ENG-SF22025-R4-CDs.pdf Markup Summary

Subject: Text Box
Page Index: 2
Date: 6/4/2024 4:58:23 PM
Author: eschoenheit
Color: █
Layer:
Space:
Page Label: [2] C2.2

***MODIFIED RURAL GRAVEL LOCAL ROADWAY (EXISTING)**
 SCALE: NOT TO SCALE

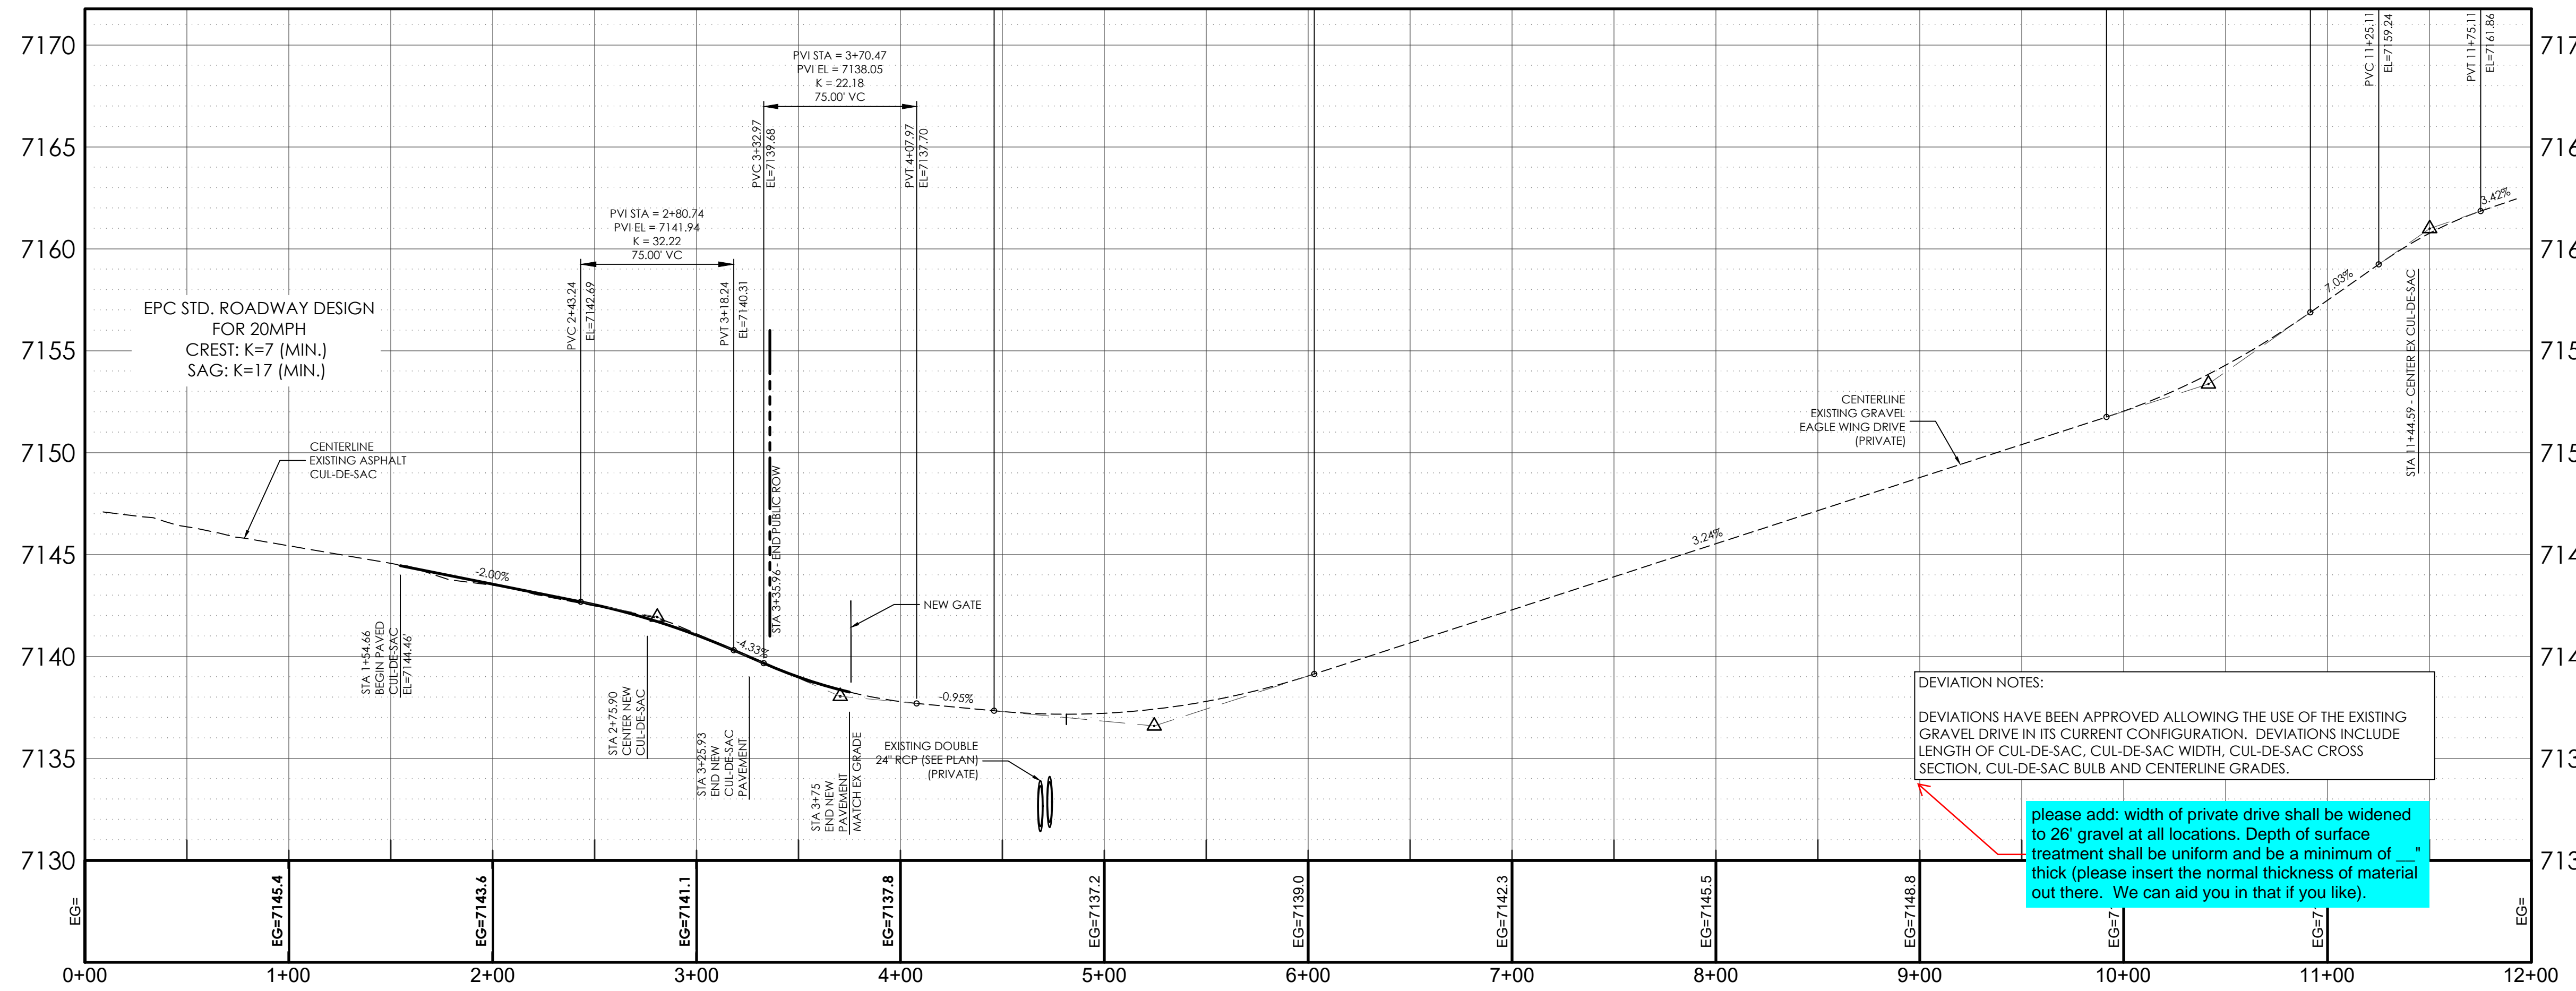
Please depict where the proposed culvert is for lots 3,4,5,6 as detailed in the FDR on page 12 and note when this would be installed.

please add: width of private drive shall be widened to 26' gravel at all locations. Depth of surface treatment shall be uniform and be a minimum of ___" thick (please insert the normal thickness of material out there. We can aid you in that if you like).

call out thickness

add note: no grading on 'others' property without appropriate permissions.

I recommend you also write this when adding other culverts.
